Attachment 1 – Department's Comments on RTS dated 21 December 2021 (SSD-10396)

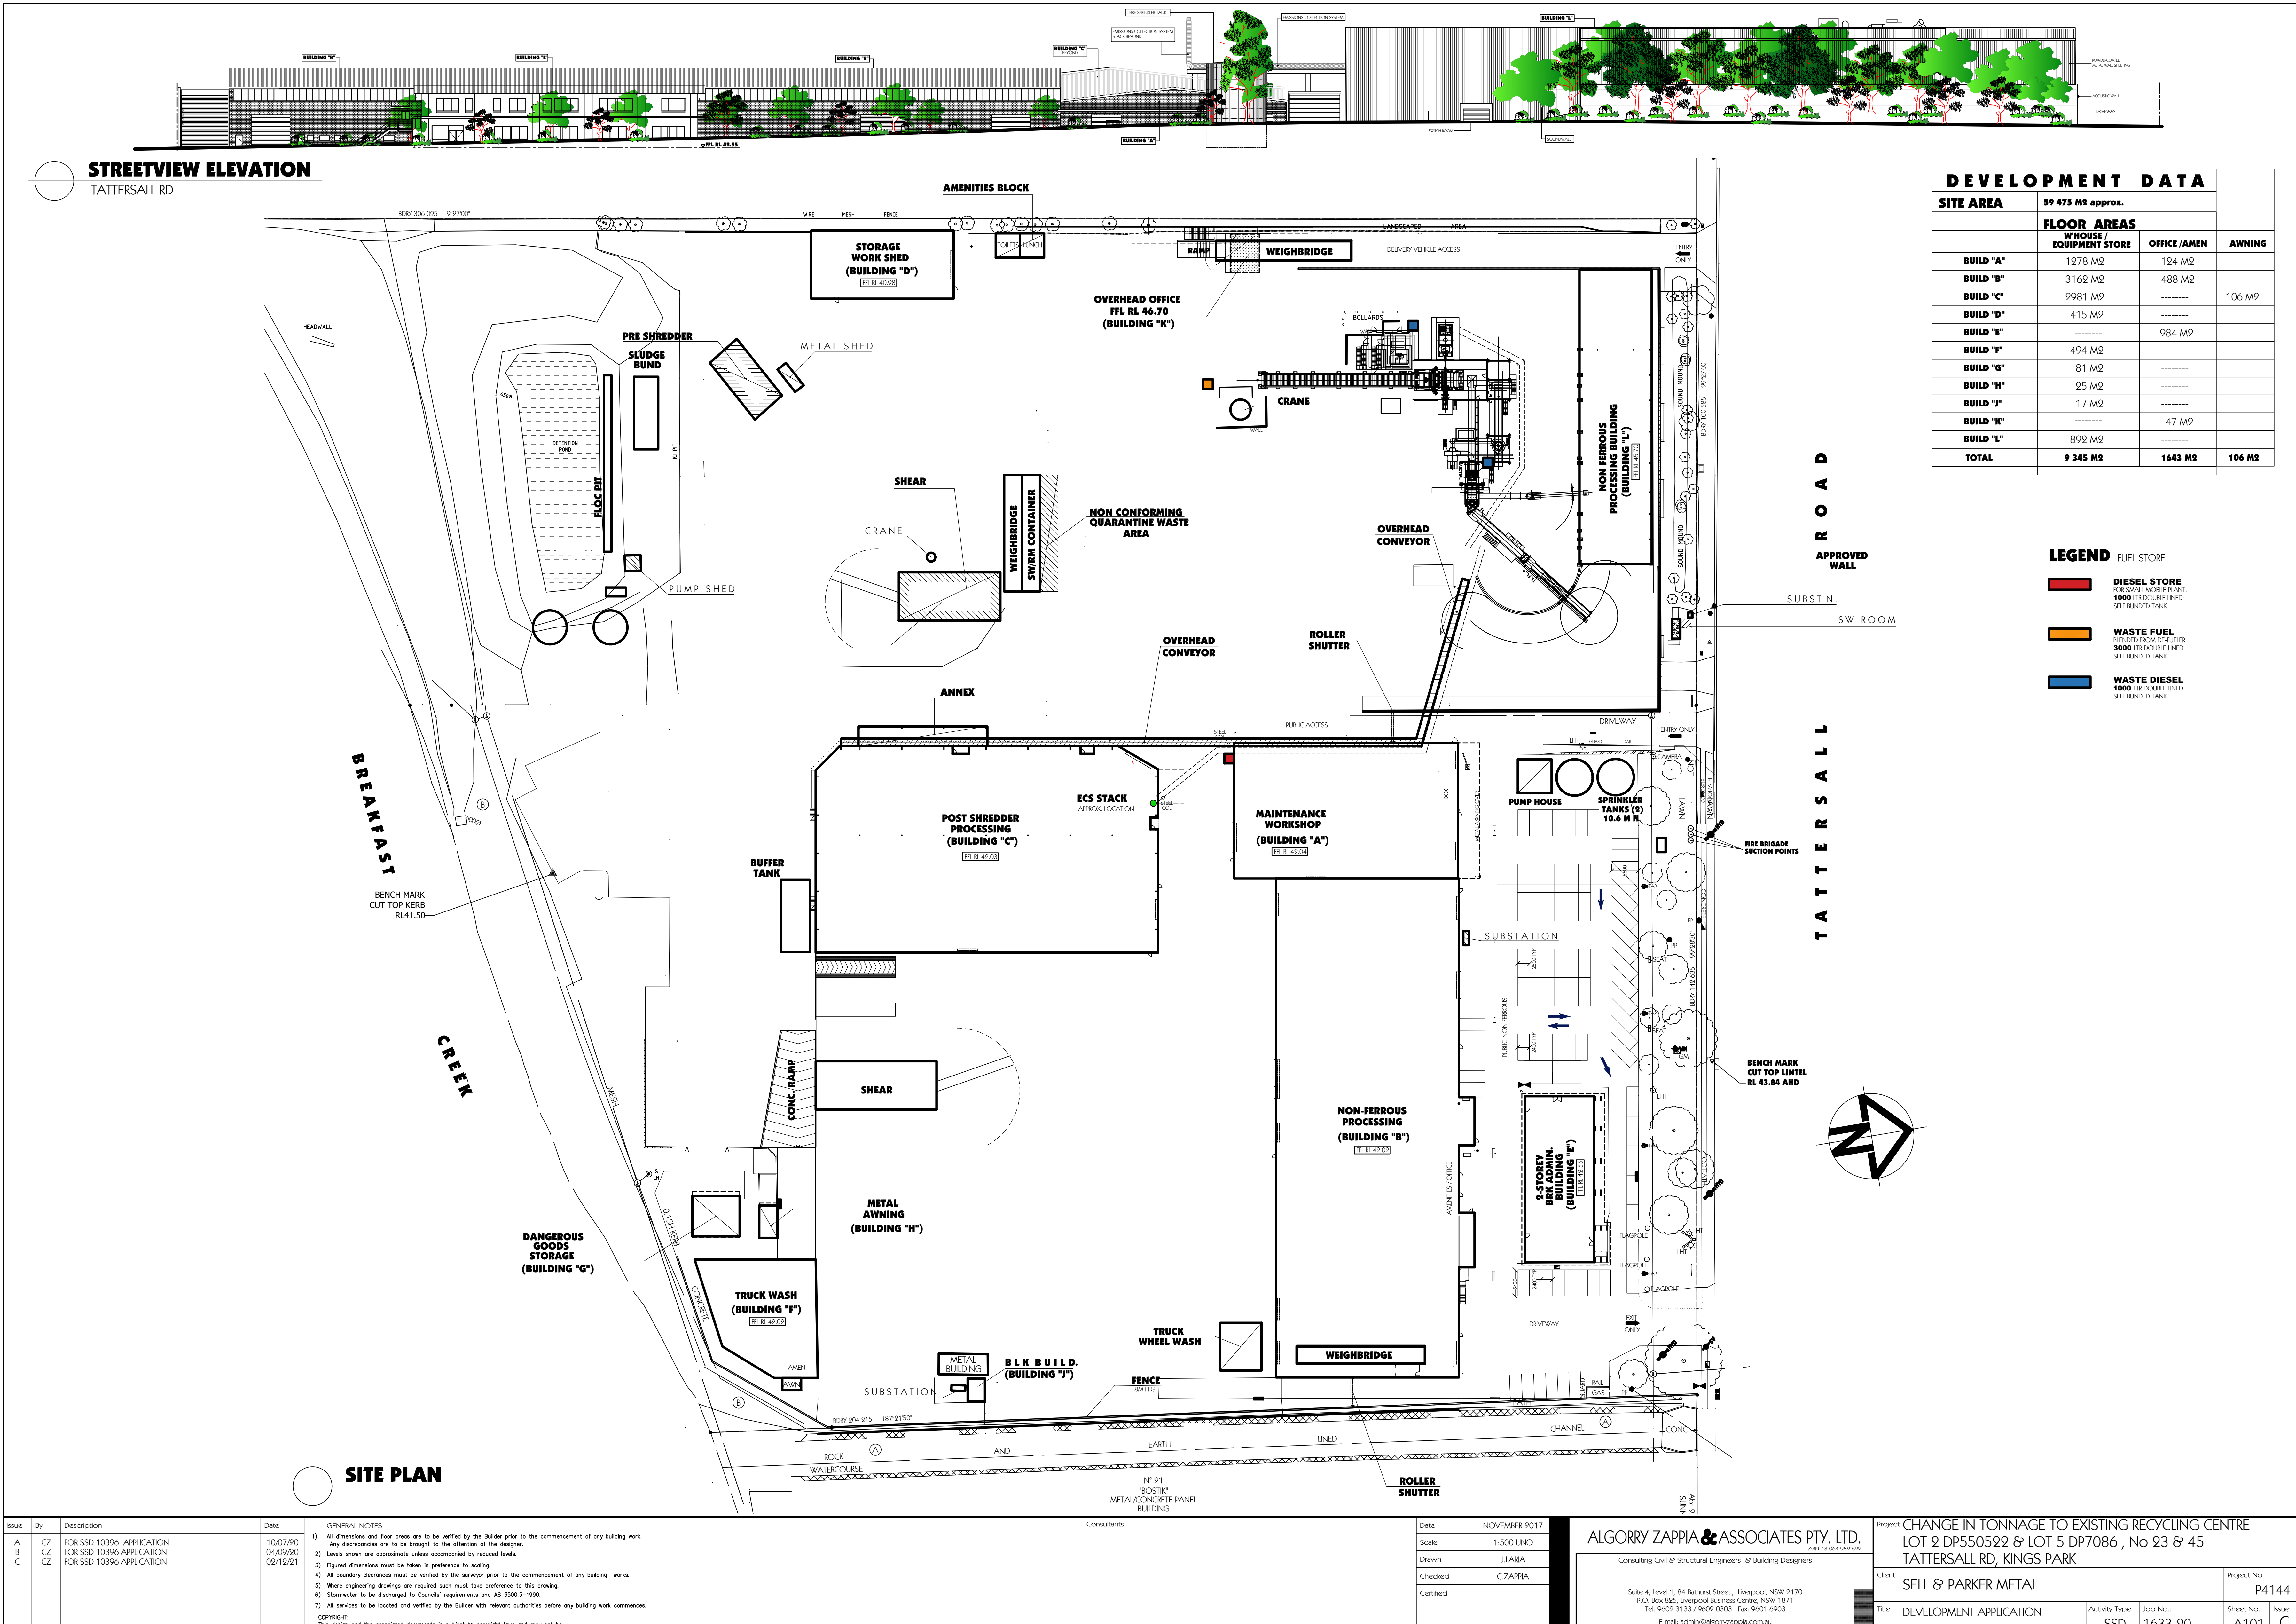
- The Department notes the Stockpile Plan (Final Stockpile Plan Approved by LEC Proceeding 2020/00365487) has been described as an 'end of day' plan. Please provide a worst-case working stockpile plan (rather than an end of day plan) which shows drop off and loading points and demonstrates that heavy vehicles can access the active site, stockpiles and relevant buildings.

- It is unclear from the swept paths shown on the Stockpile Plan if the access routes to the west of the combustible stockpiles, to the north of Building B and between Building C and the existing shear are intended for use by the largest vehicle accessing the site. Please update the plan to demonstrate which vehicles can access the shown paths.

- Show, on the site plan, where the bins, large spare parts and cranes would be stored if the 'storage area' to the south of Building C is used for queueing trucks.

Client	SELL & PARKER METAL	Project No.	P4144
Title	DEVELOPMENT APPLICATION ELEVATION & SECTION	Activity Type	SSD
Job No.	1633-20	Sheet No.	A101.2
Issue	E

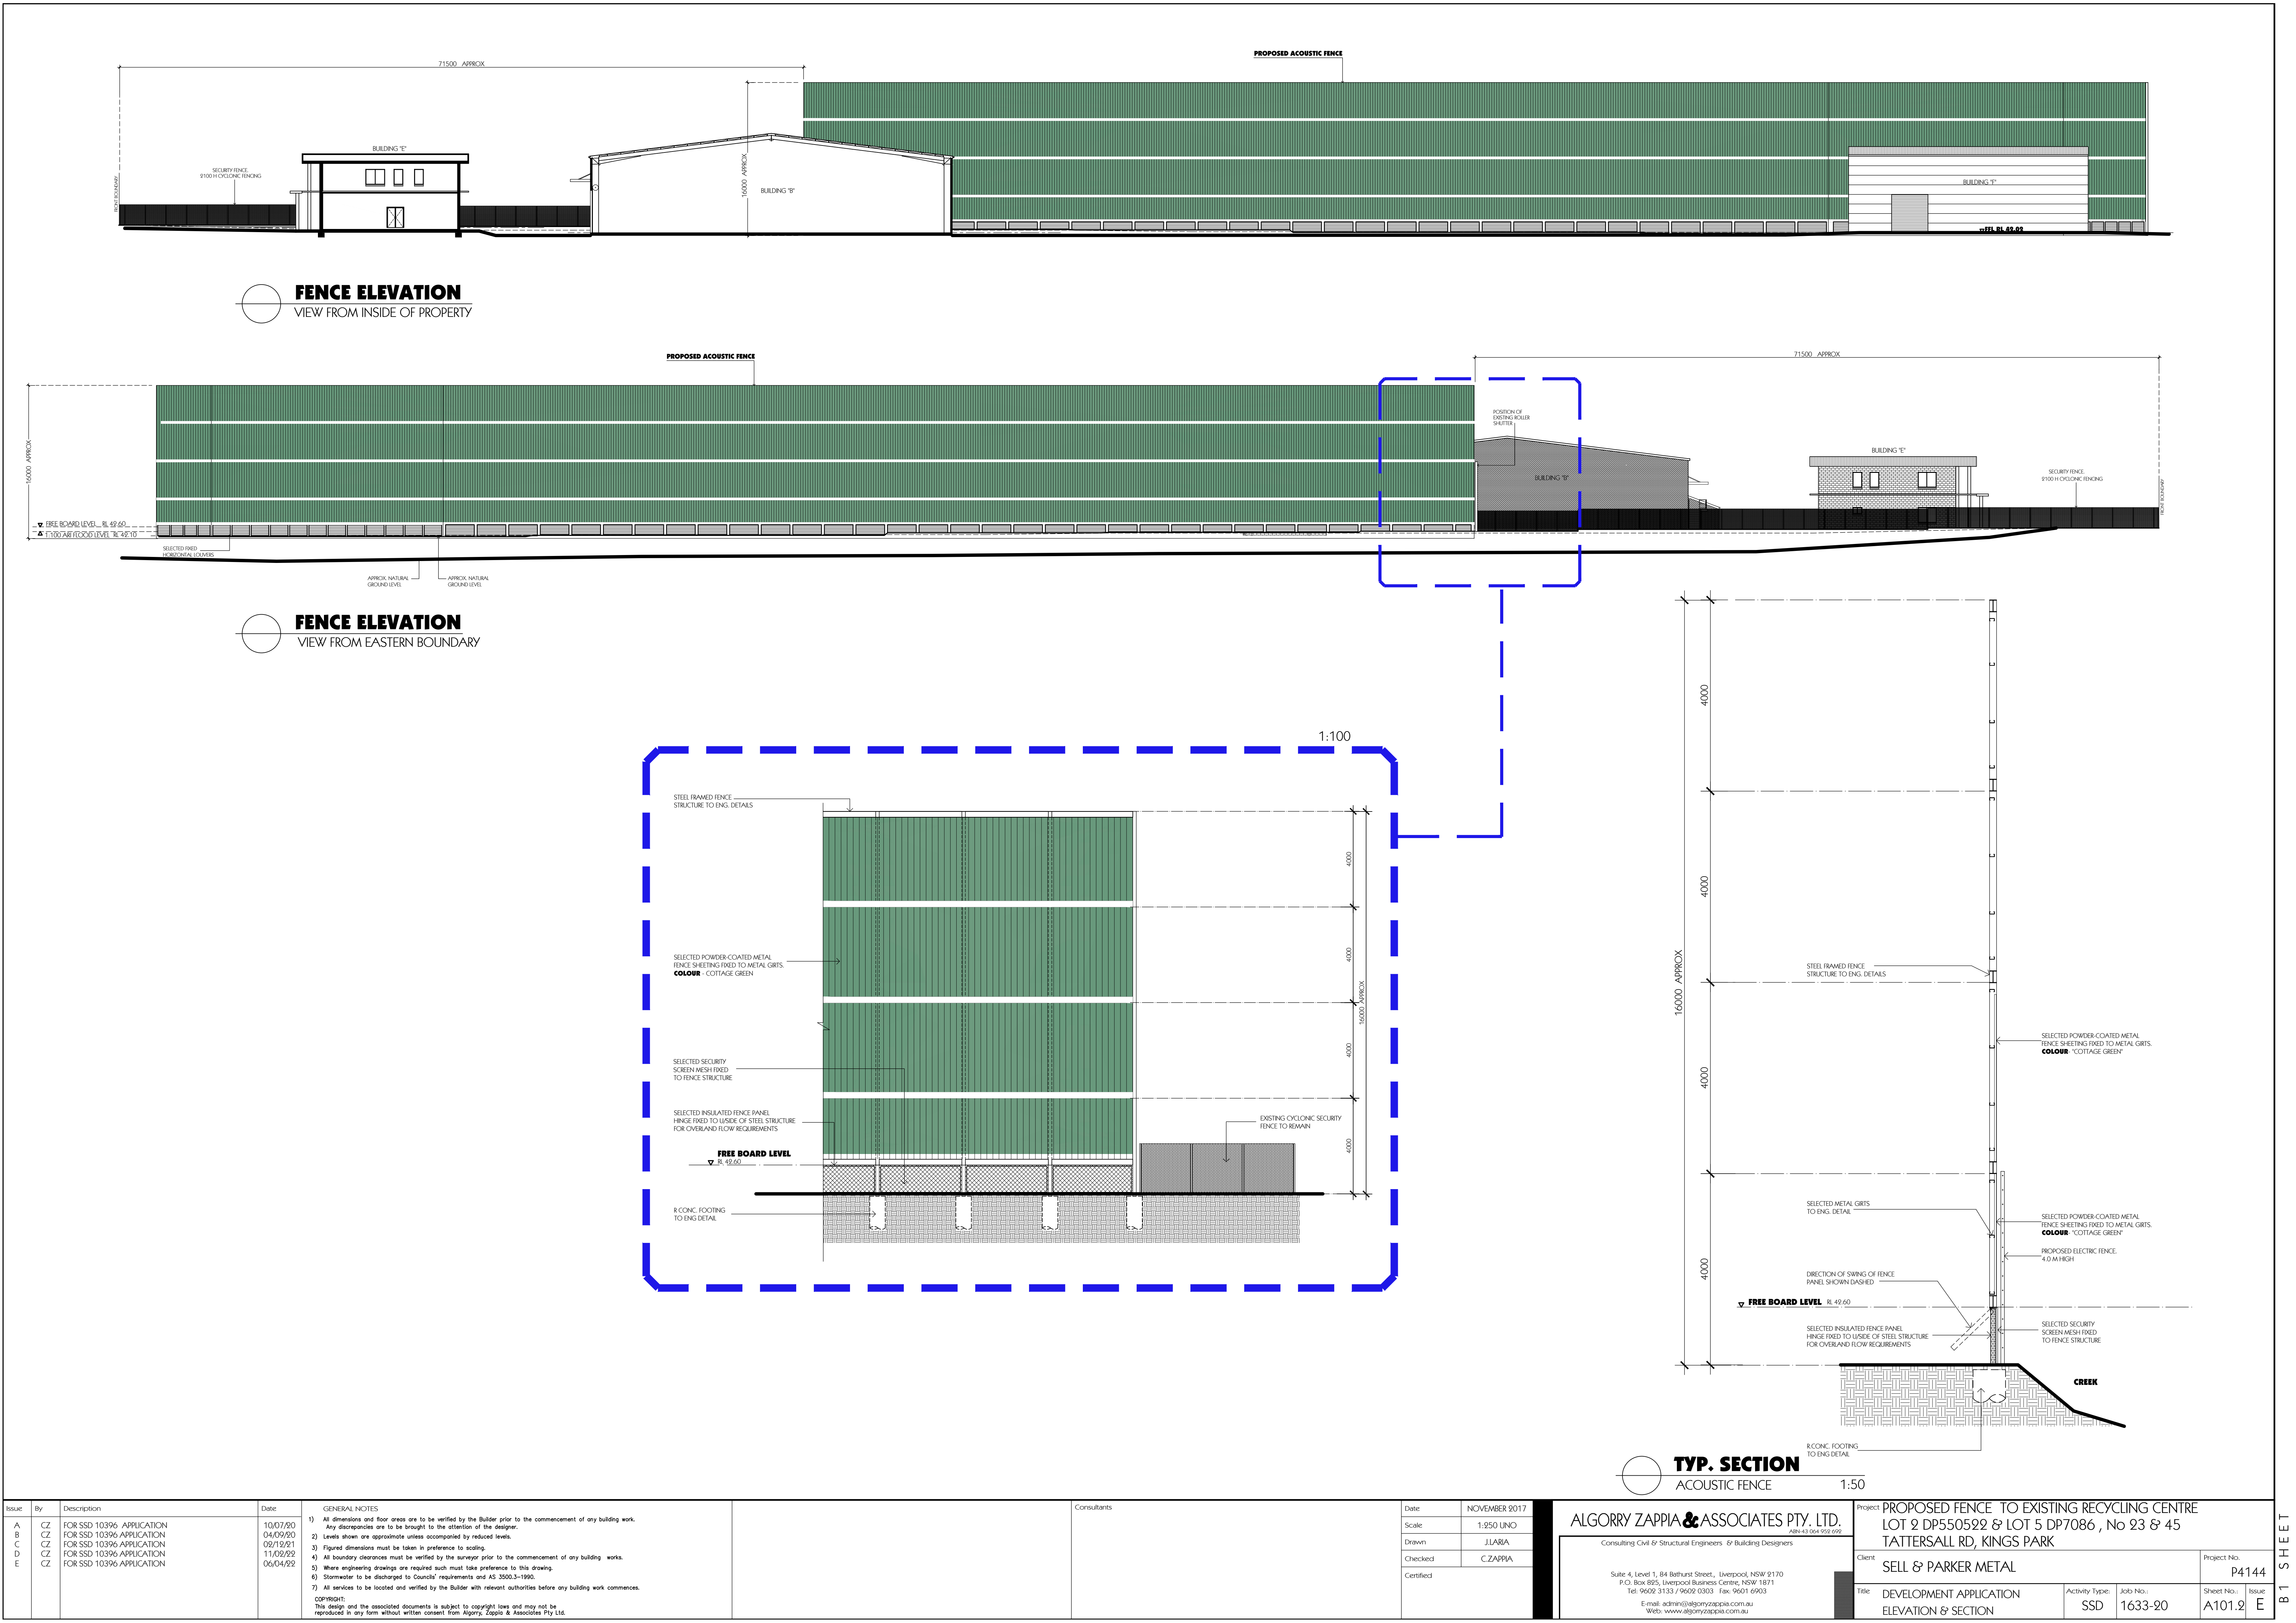
- Provide plans (including elevations and sections) of the proposed 16 m high noise wall along the south-eastern boundary of the site and ensure all site plans include the proposed noise wall.
